**From:** Maria Tomalova  
**Sent:** 18 November 2022 15:36  
**To:** Planning.Responses  
**Subject:** FW: 23452 Stakers Farm, Yapton - Y/52/22/DOC Designers Response  
**Attachments:** 201\_A\_Proposed Drainage and Levels Layout Plan.pdf; 501\_B\_Construction Details.pdf; Permeable gravel surface subbase hydraulic calculations.pdf; 103\_A\_Existing and Proposed Impermeable Areas.pdf

**From:** Kyanna Hodge [REDACTED]  
**Sent:** 11 November 2022 17:06  
**To:** Sarah Burrow <Sarah.Burrow@arun.gov.uk>  
**Cc:** CEP | Reception [REDACTED]; Stuart Magowan <[REDACTED]>; Zac Denton  
**Subject:** 23452 Stakers Farm, Yapton - Y/52/22/DOC Designers Response

Further to LLFA Response dated 20 September 2022 for information on the Discharge of Condition application Y/52/22/DOC, we have attached updated drainage drawing 201A\_Proposed Drainage Plan together with revised calculations and construction details based on the comments received.  
We reply to the following responses below in *green* as follows:

DWG NO.
103

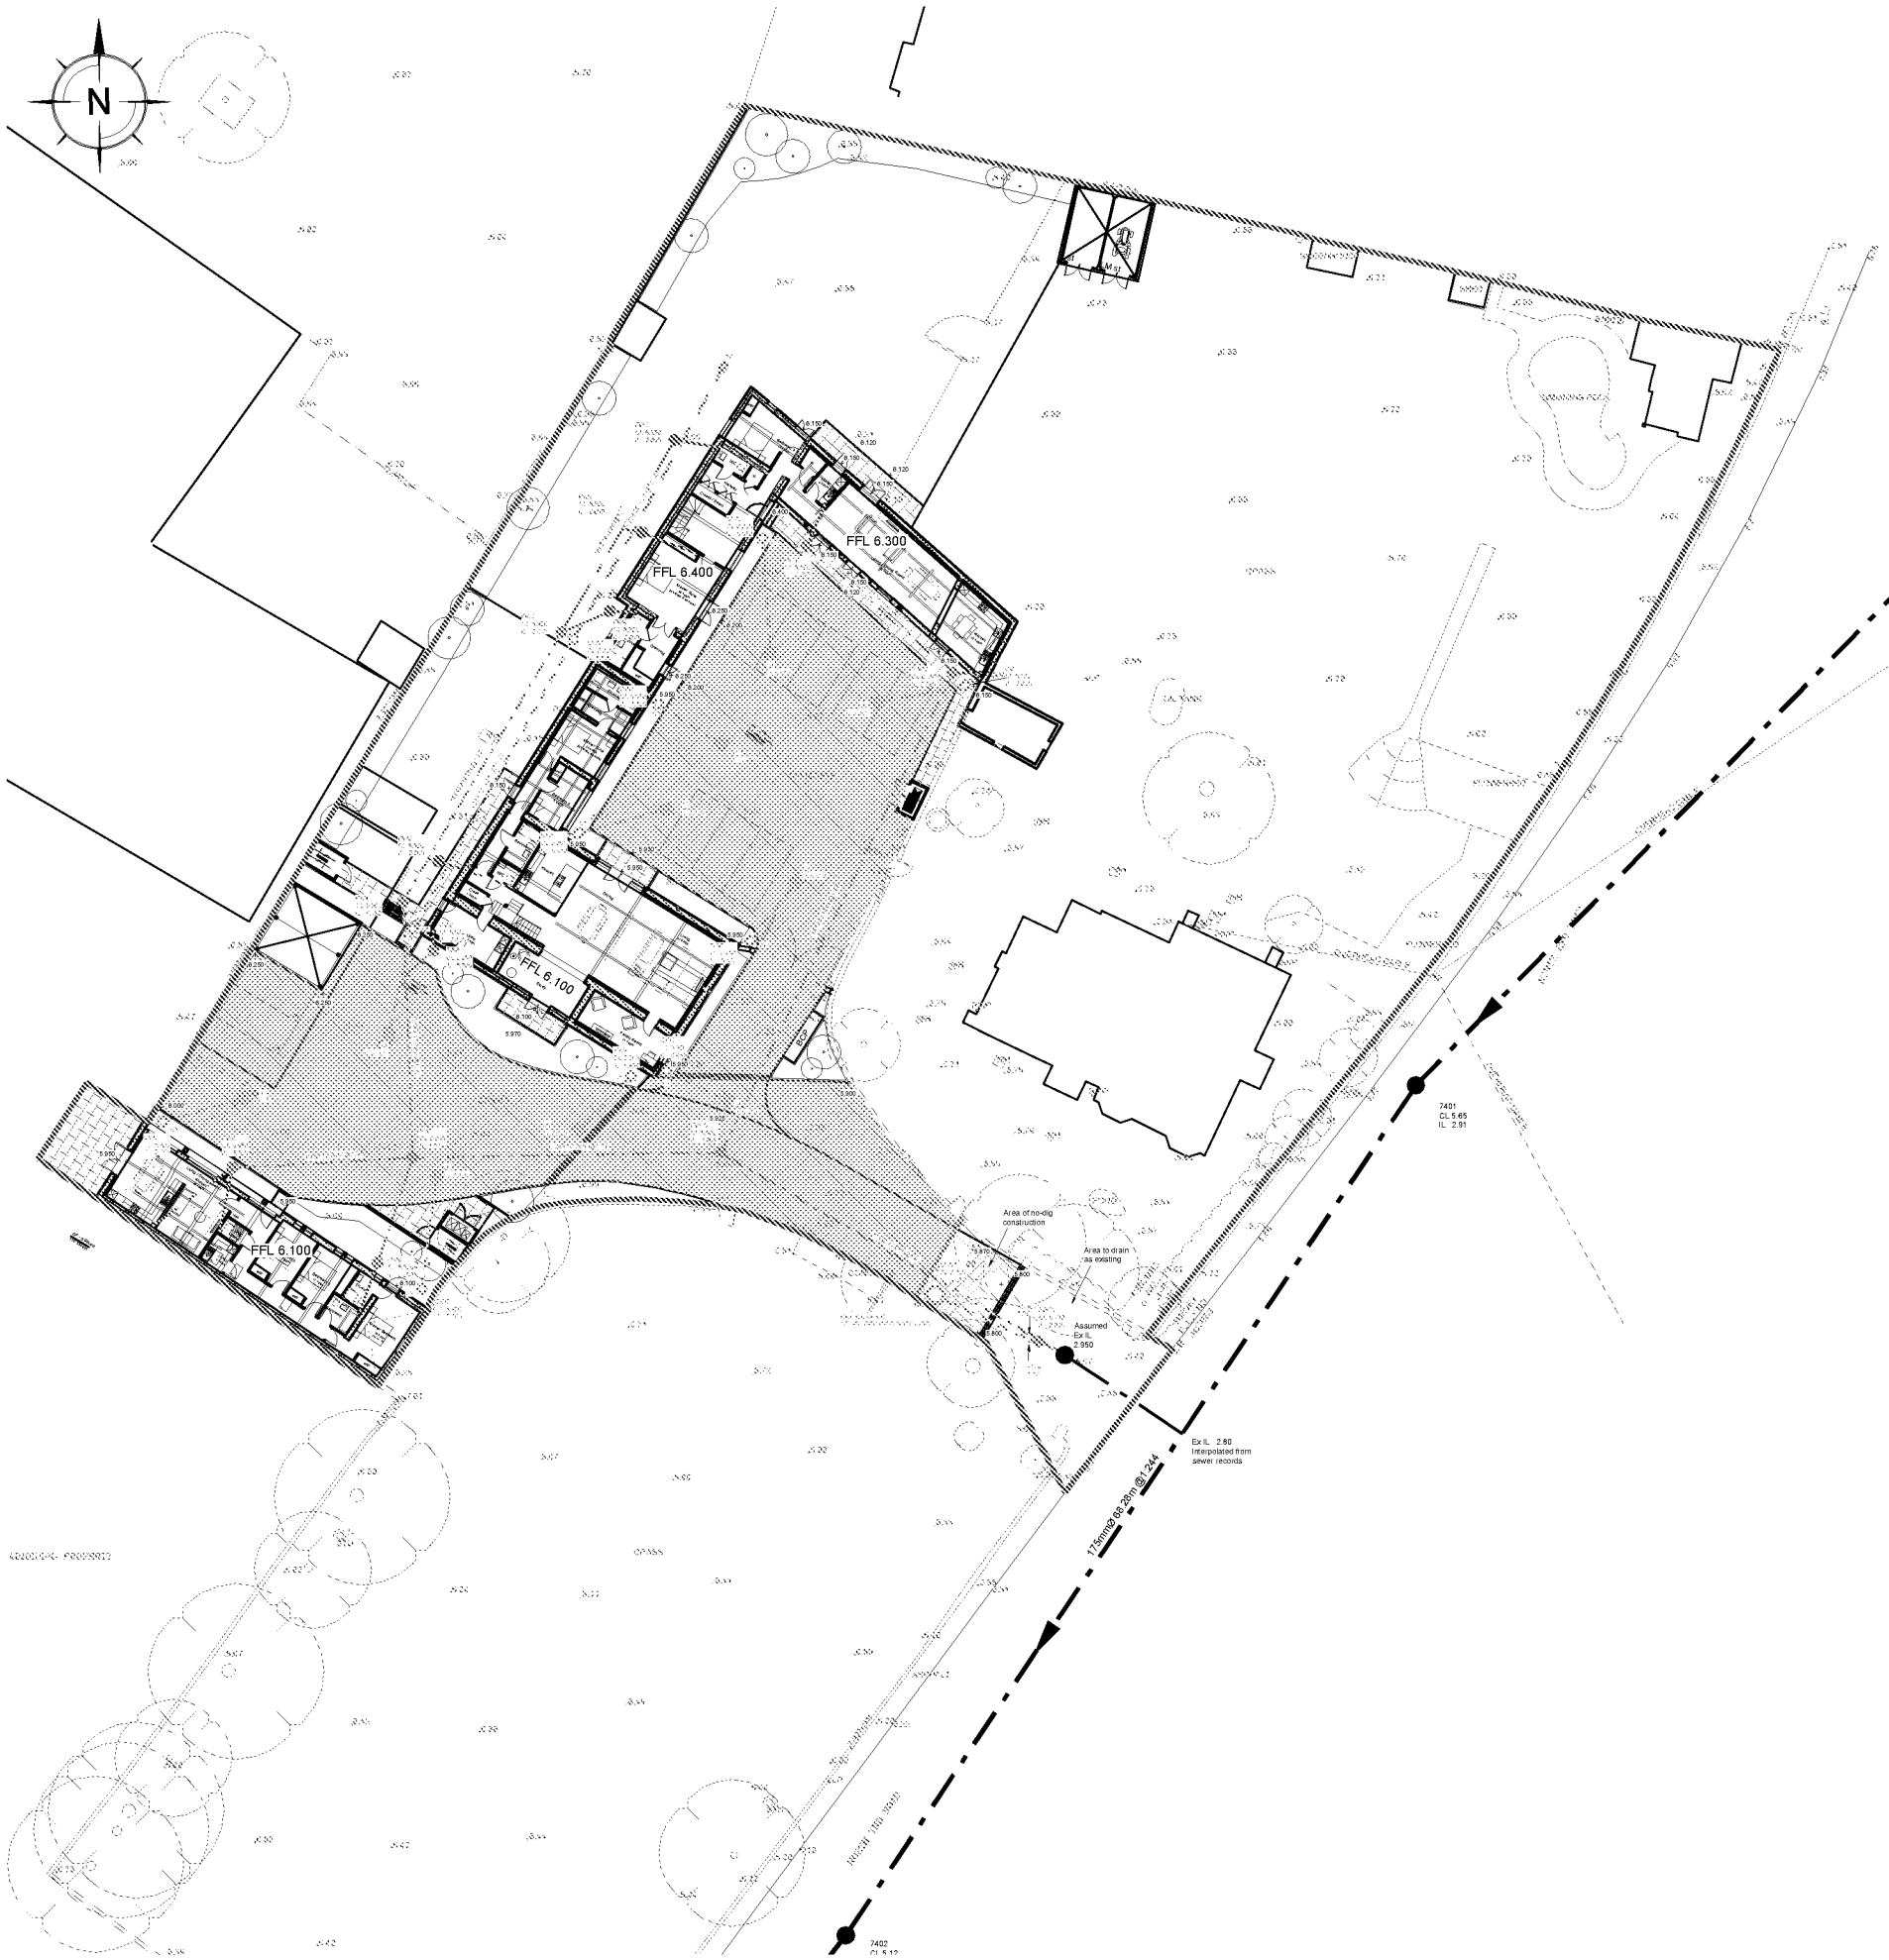
6. The drainage calculations should typically include an allowance for urban creep. In this case, we are satisfied that there are limited opportunities for including additional hardstanding, however, the applicant should provide a justification for its exclusion within the report or calculations. 10% Urban creep has been included within the calculations. The impermeable area of the proposed roofs is 715m<sup>2</sup> and with 10% urban creep of the roofs of 72m<sup>2</sup>, the total area used for the roof is 787m<sup>2</sup> and the area for the carpark used is 1000m<sup>2</sup>. The total area used for the calculations including the urban creep is 1787 m<sup>2</sup> or 0.179ha as shown on drawing 103A\_Impermeable Areas Plan and the updated calculations.

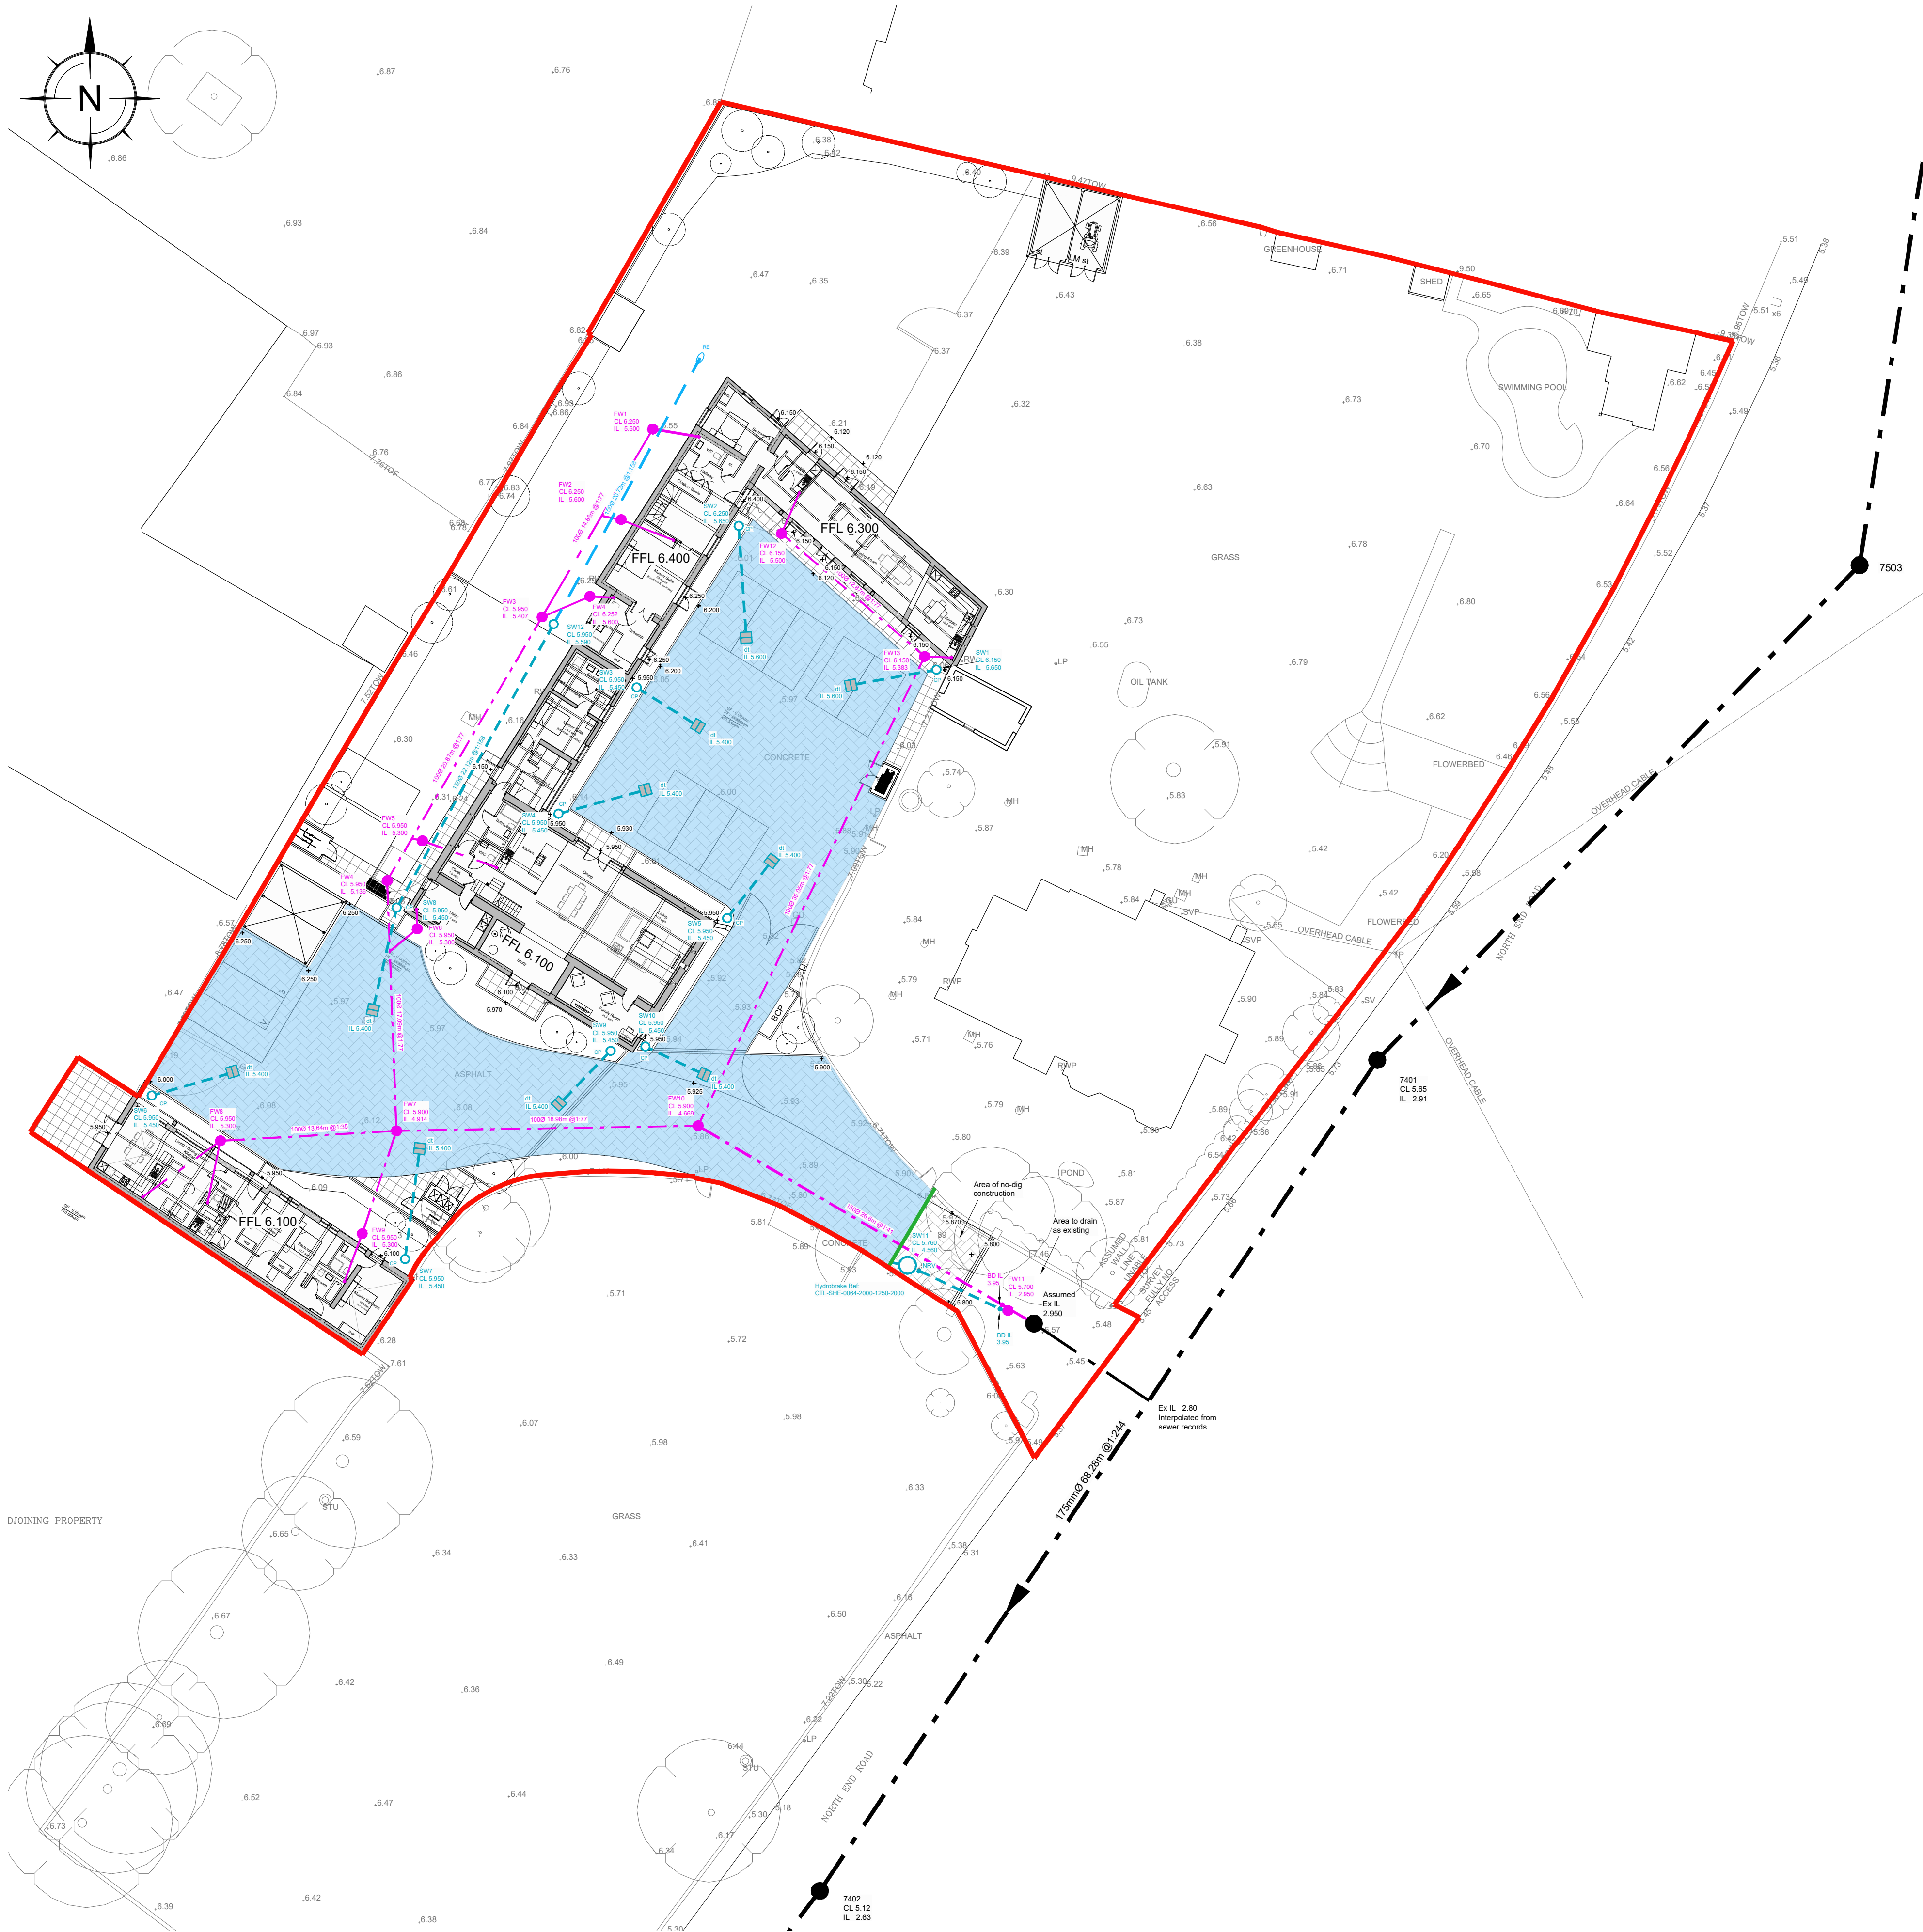
1. Additional information is required on the design drawings.
  - The invert level for the diffusion boxes has been provided, however, we request that the invert levels of the paving sub-base / bed levels are also provided in these locations, as the section drawing shows these to be different. This is also being requested to enable us to check that the diffusion boxes are located above the critical 1:10 (+40% climate change) water level within the sub-base. Without these values insufficient information is available to confirm that the peak water level within the paving sub-base will be contained within the sub-base. The paving subbase formation level is 5.970m for the northern area and 5.400m for the southern area as shown on the drainage drawing 201A, copy attached. The design is not based on infiltration to ground and there is no requirement within Arun District Council Guidance or National Planning Practice Guidance for distribution tanks to be located above the 1 in 10 year storm event for storage systems

- Service corridors for other services provided to the buildings should be shown, or a statement provided detailing how these will be successfully implemented within the scheme. Service trench corridors have been included within the drainage strategy noted on drawing 201A, copy attached.

MANHOLE WITH HYDROBRAKE
(Scale 1:25)

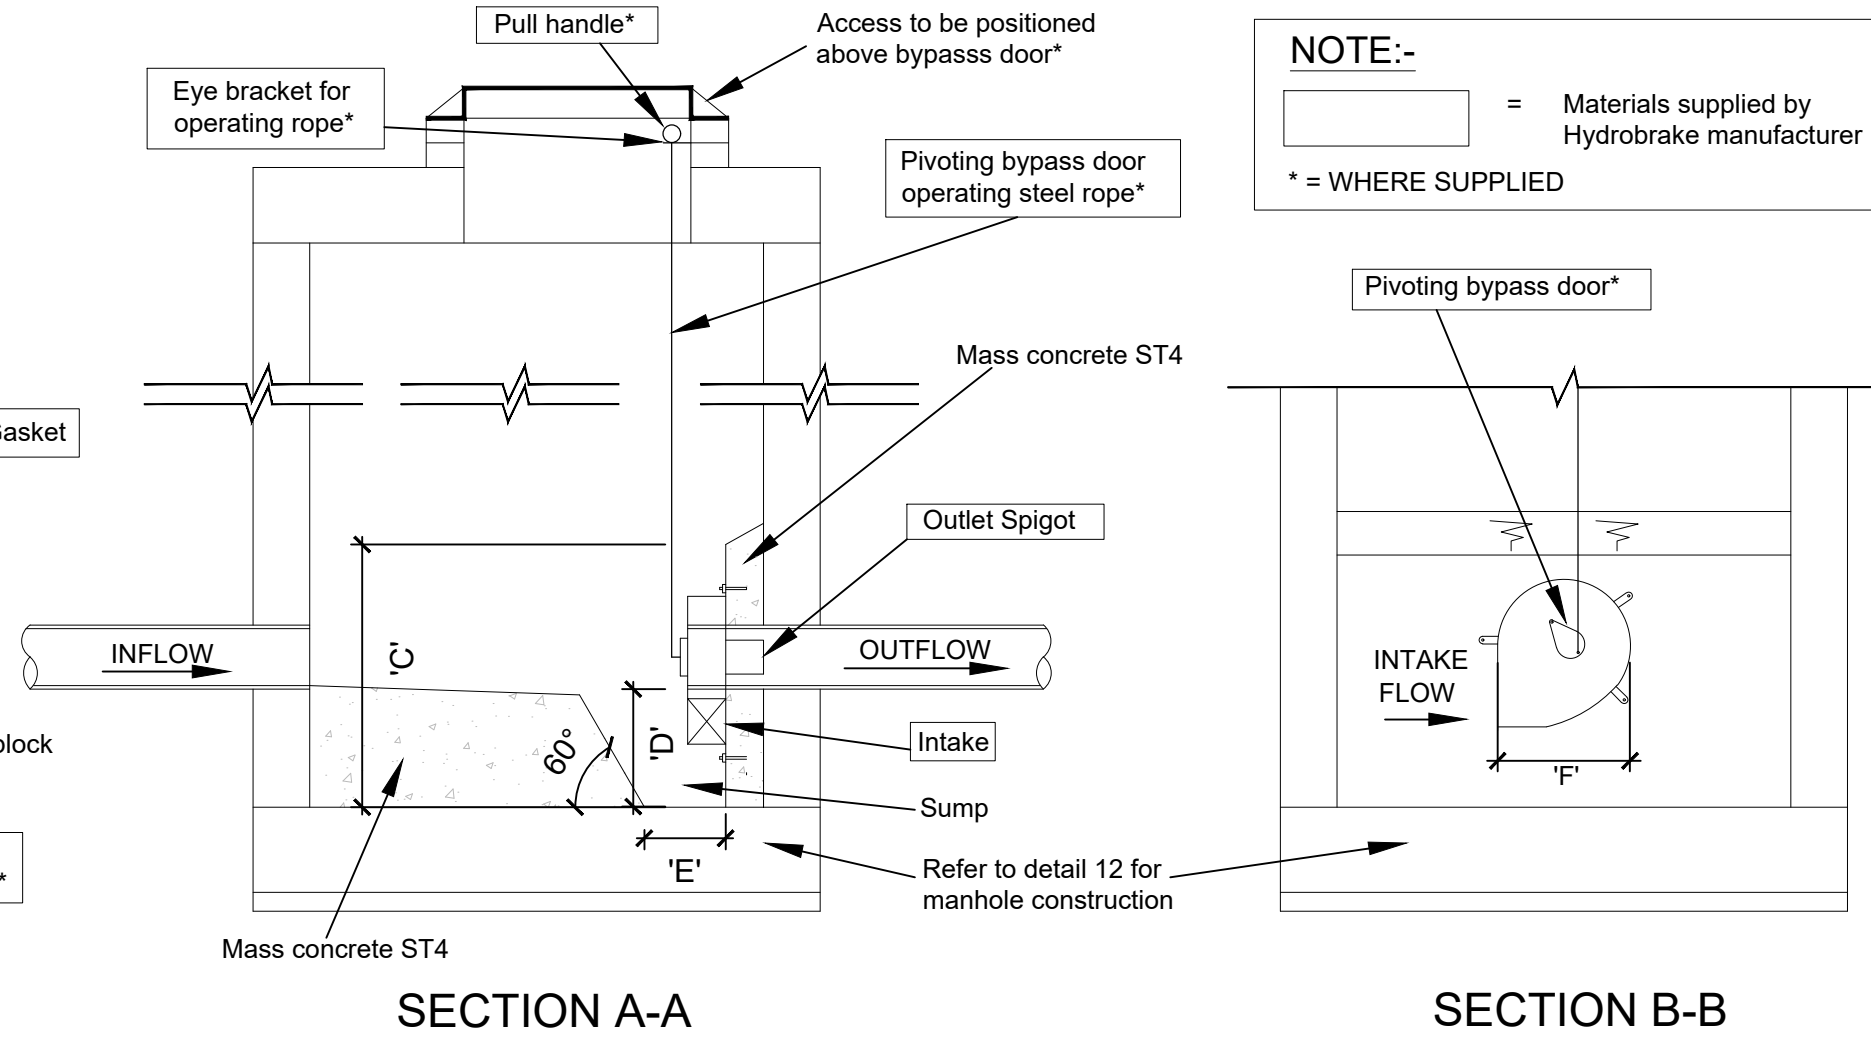
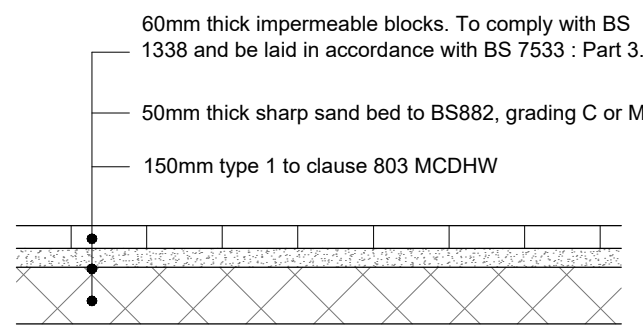
- The Hydro-Brake manhole is deeper than 1m, building regulations recommends manholes of this depth to have rungs or a ladder, which is not shown on the cross-section drawing. Justification for why this has not been shown should be provided, or the drawings updated accordingly. Construction details have been updated, hydrobrakes are proposed at less than 1m in depth, please see drawings 5018\_Proposed Construction Details and 201A\_Proposed Drainage Plan
